**From:** Sue Howell <Sue.Howell@arun.gov.uk>  
**Sent:** 12 December 2024 18:09  
**To:** Planning.Responses <Planning.Responses@arun.gov.uk>  
**Cc:** Kathryn Welch <Kathryn.Welch@arun.gov.uk>  
**Subject:** Planning Consultation on: LU/246/24/PL

#### Response to Planning Application

**Application ref:** LU/246/24/PL

**Description:** Demolition of existing structures and development of land to create 10 No. residential dwellings, landscaping, access, car parking and cycle parking. This application may affect the setting of listed buildings, is in CIL zone 2 and is CIL liable as new dwellings.

**Figure 1.** Proposed landscaping plan for the development at Land at Toddington Lane, reproduced from Studio gb, dated September 2024 (drawing no. TLN-SGB-00-GF-DR-L-101).

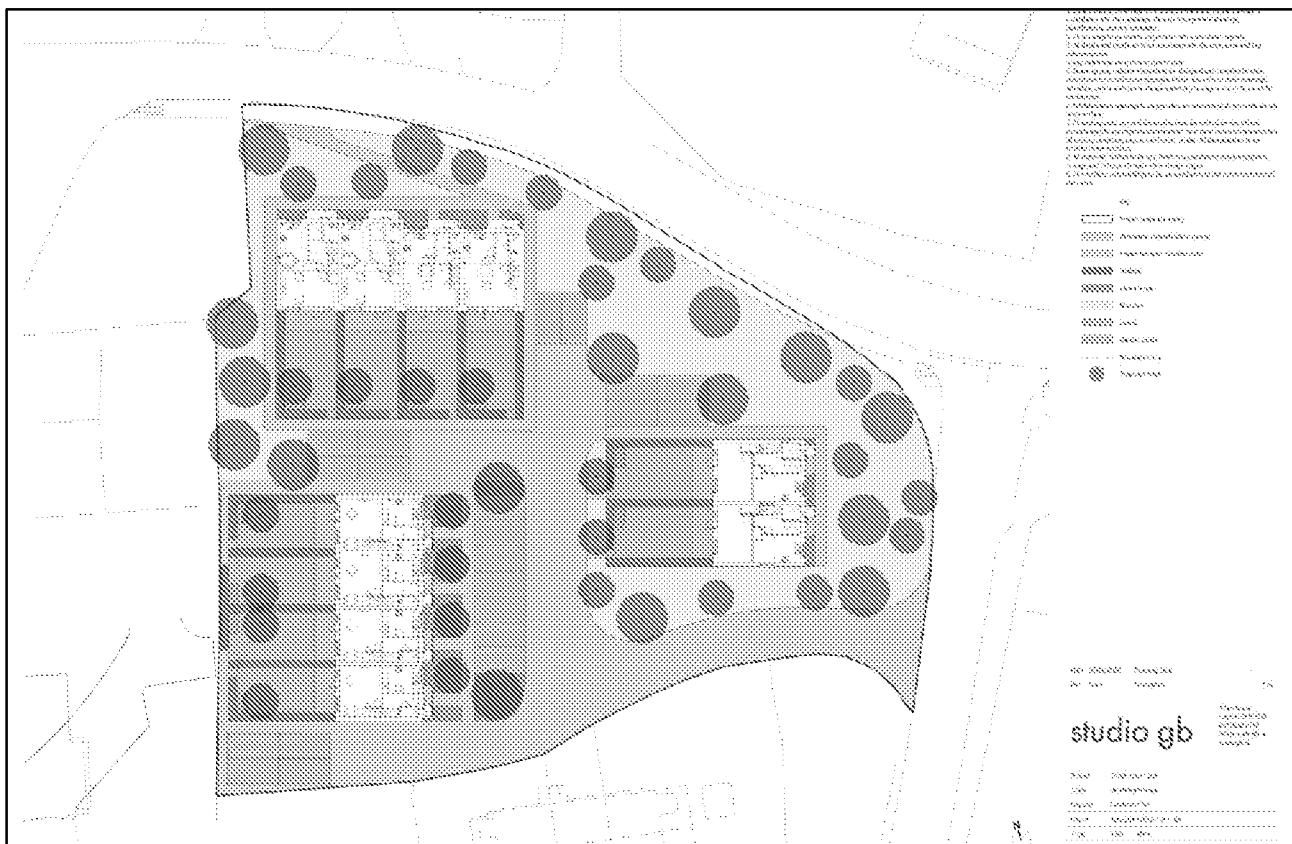
A site plan, Landscape GA L-101, Planting strategy, Landscape Statement and Design and Access statement have been submitted. The detail provided within these drawings is indicative only and would require further landscape drawings to detail actual quantities, planting densities and size at time of planting.

With a development of 10no dwellings, Public Open Space is not a requirement, however **developments of 9 or more dwellings are required to provide on site provision of LAP facility and therefore suitable location and quantum of greenspace to accommodate this.** LAP provision is not indicated on the plans and would be a requirement, which would need to be shown. Location of the indicated open area surrounding the semi-detached plots is banked or adjacent to a roadway and therefore may not be suitable location for LAP provision.

It is noted that much of the green infrastructure proposed is located within private garden locations, with trees and hedges which have the potential to be removed by the residents and therefore not a guaranteed long stay of the scheme. This in turn will effect Biodiversity Net Gain calculations. Green infrastructure proposals should be included within the site outside of private dwelling remits.

The landscape scheme submitted within the DAS is indicative only and will require plan submission of proposals to include quantities, species choice, position, densities and size at time of planting. This detail is required in plan and list form and in relation to existing trees and vegetation retained in order to given a clear and adequate picture of the proposals..
